Response to Planning application from Hertfordshire County Council (T and CP GDP Order 2015)

District ref: 6/2022/0837/ADV
HCC ref: WH/11934/2022
HCC received: 20 April 2022
Area manager: Matthew Armstrong
Case officer: Steven Knight

COTE BRASSERIE 1-3 HOWARDSGATE WELWYN GARDEN CITY AL8 6AL

Installation of 2 sets of halo illuminated fascia text and 2 externally illuminated projection signs

Proposed Signs

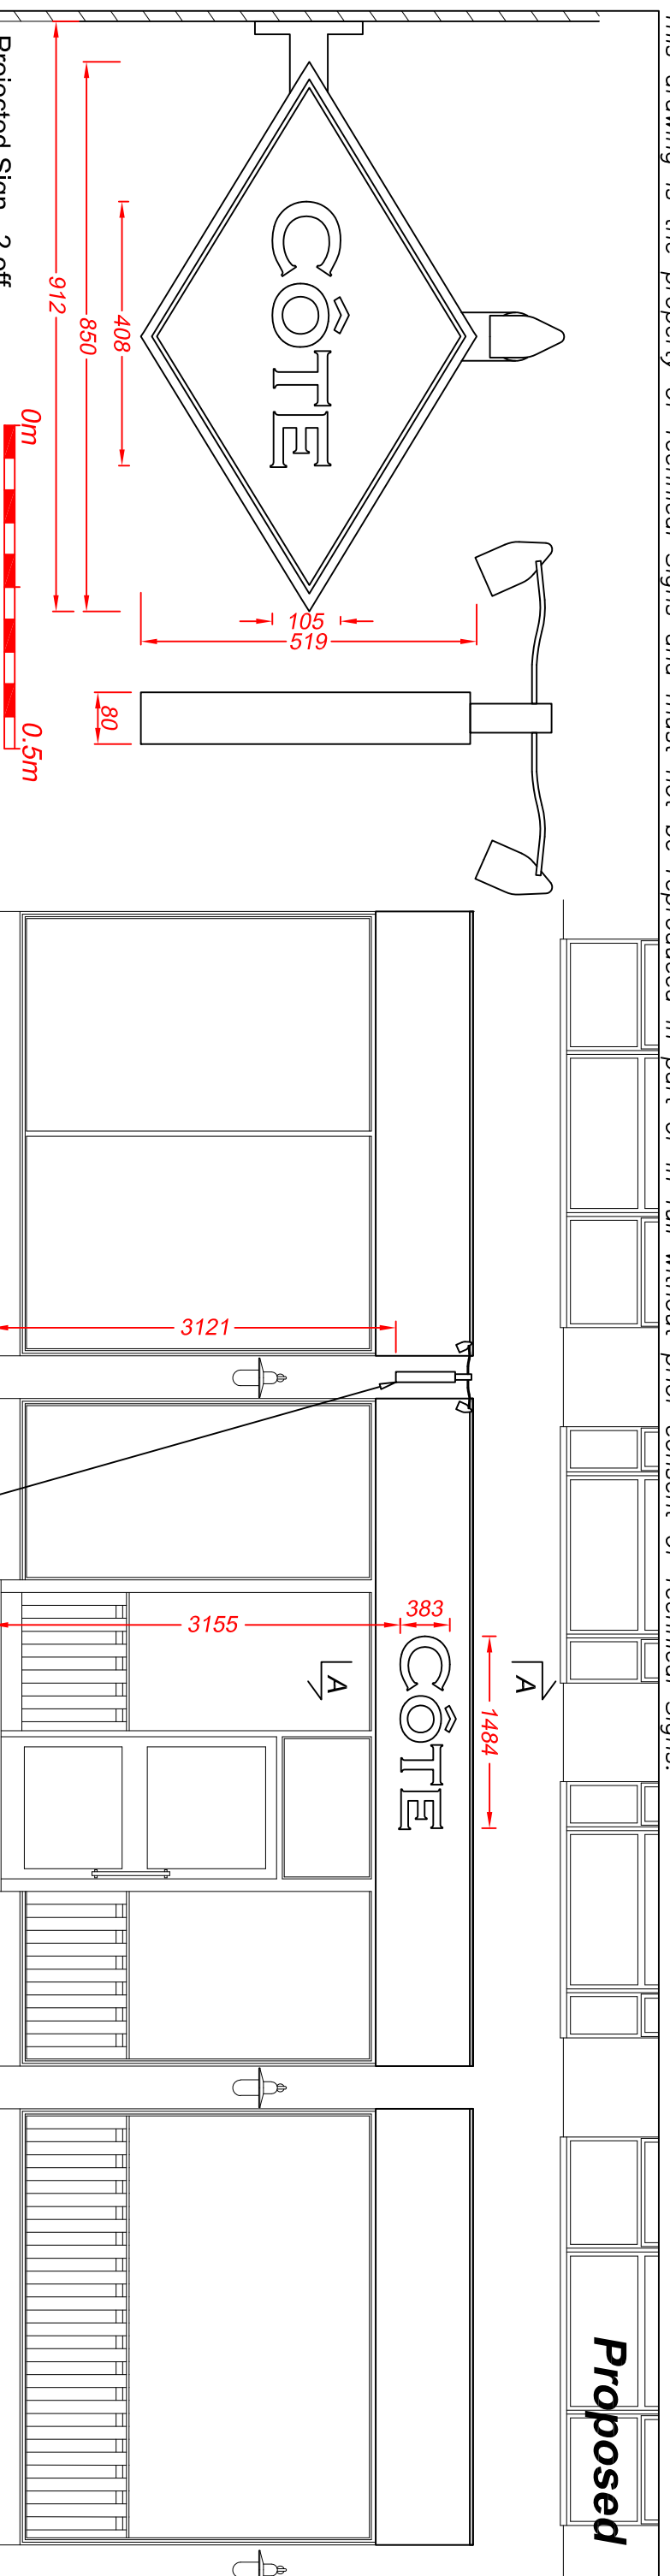
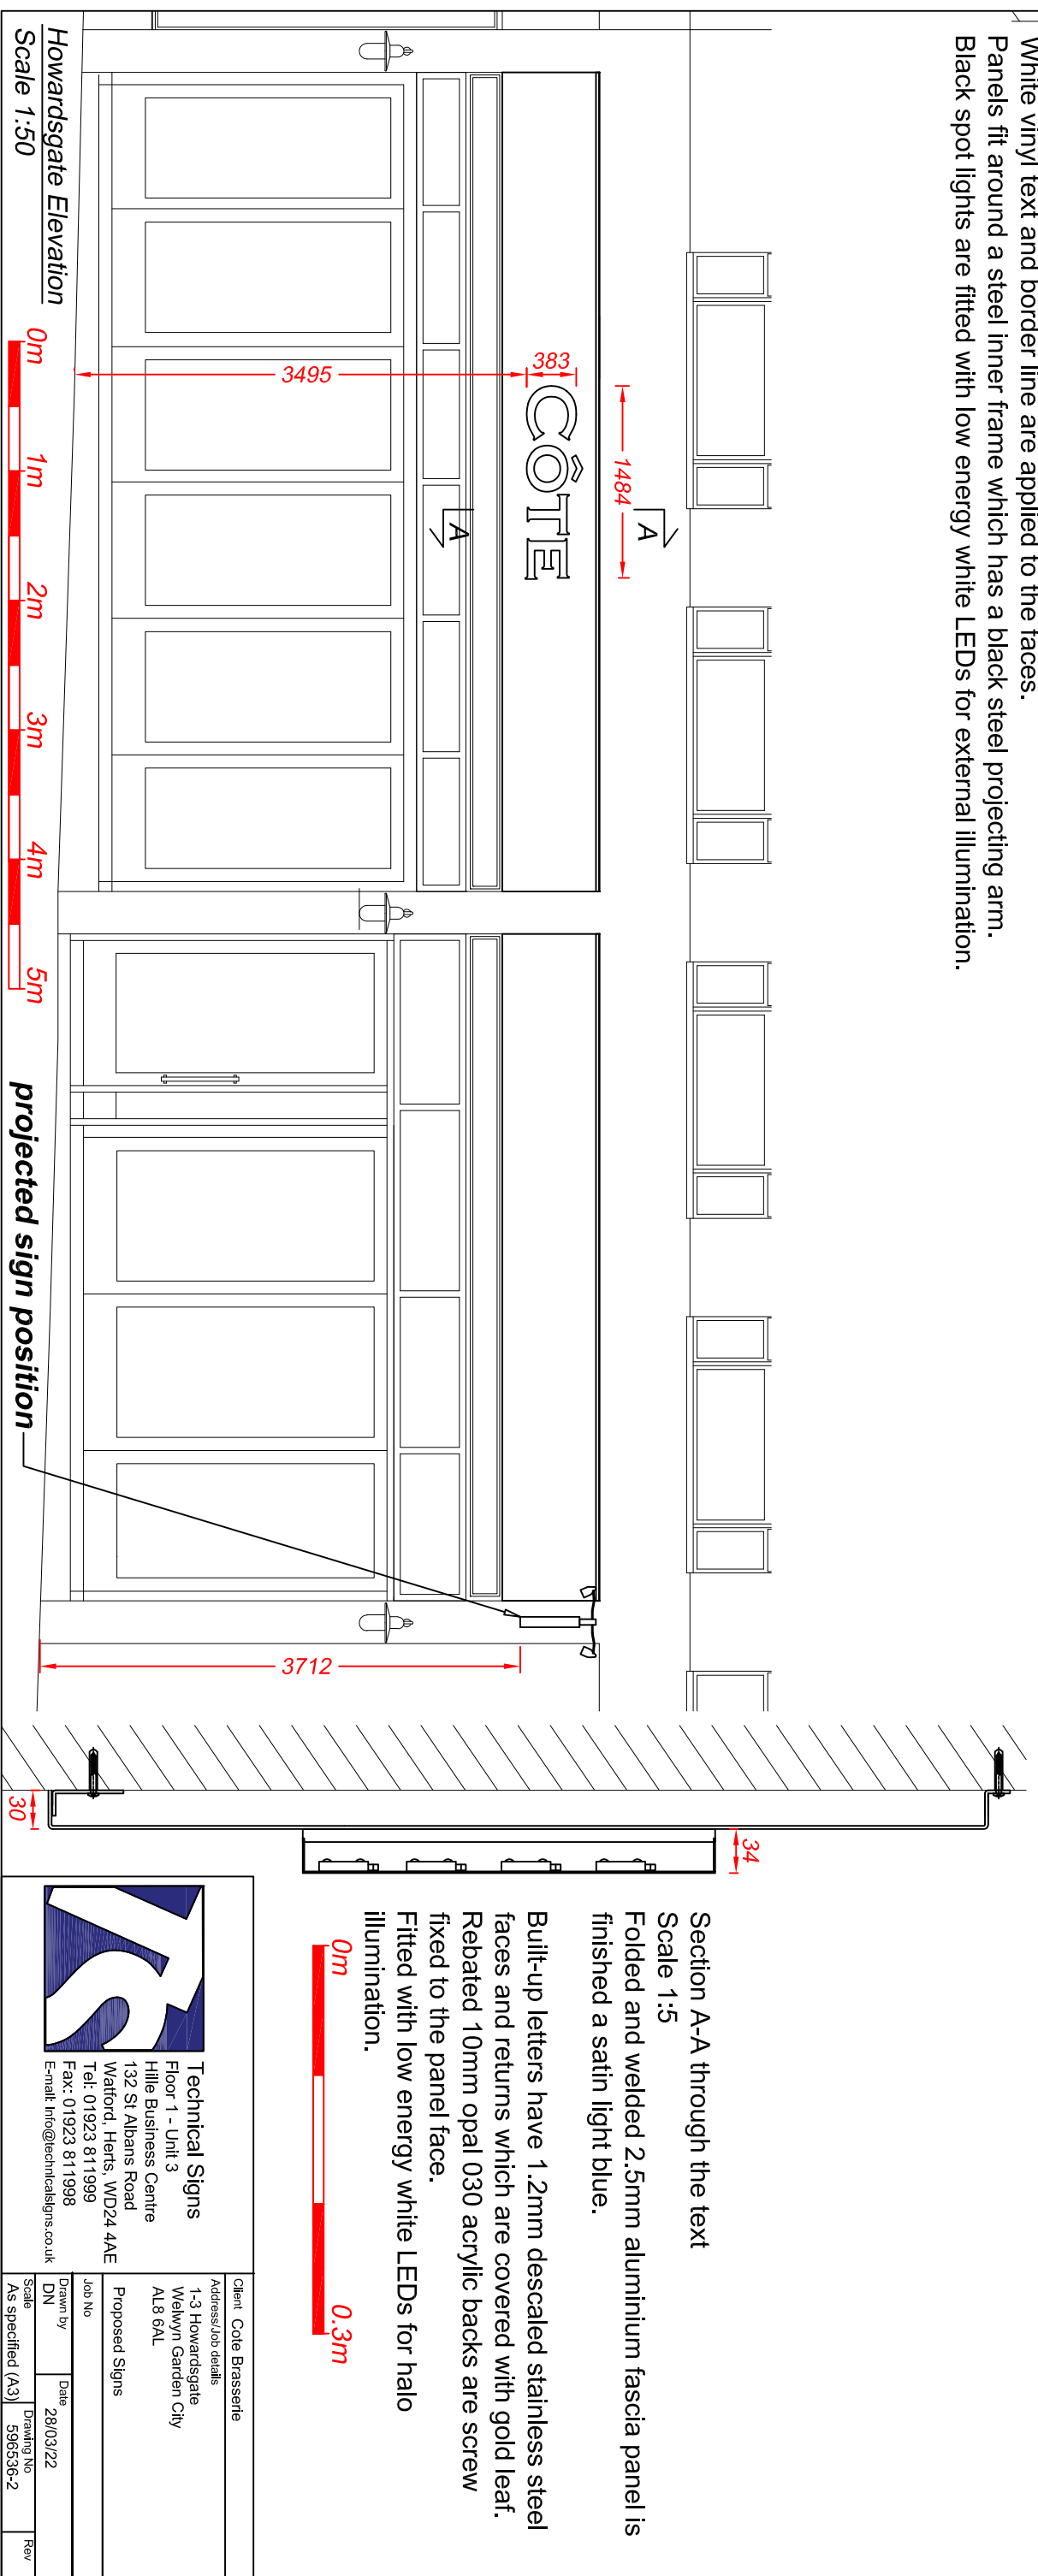
The luminance of the proposed signs is within acceptable limits based on the ILP's Professional Lighting Guide 05 – The Brightness of Illuminated Advertisements. This is an urban, street lit area with multiple other similar signs so the proposal is unlikely to be distracting or confusing to motorists.

The fascia signs will be flush to the shopfront and the projecting signs will be over 3m above the footway which is acceptable.

Prior to the first use of the development hereby permitted the intensity of illumination shall be provided at a level that is within the limit recommended by the Institution of Lighting Professionals in the publication 'Technical Report No 5: Brightness of Illuminated Advertisements' and 'Guidance Note for the Reduction of Obtrusive Light GN01:20'.
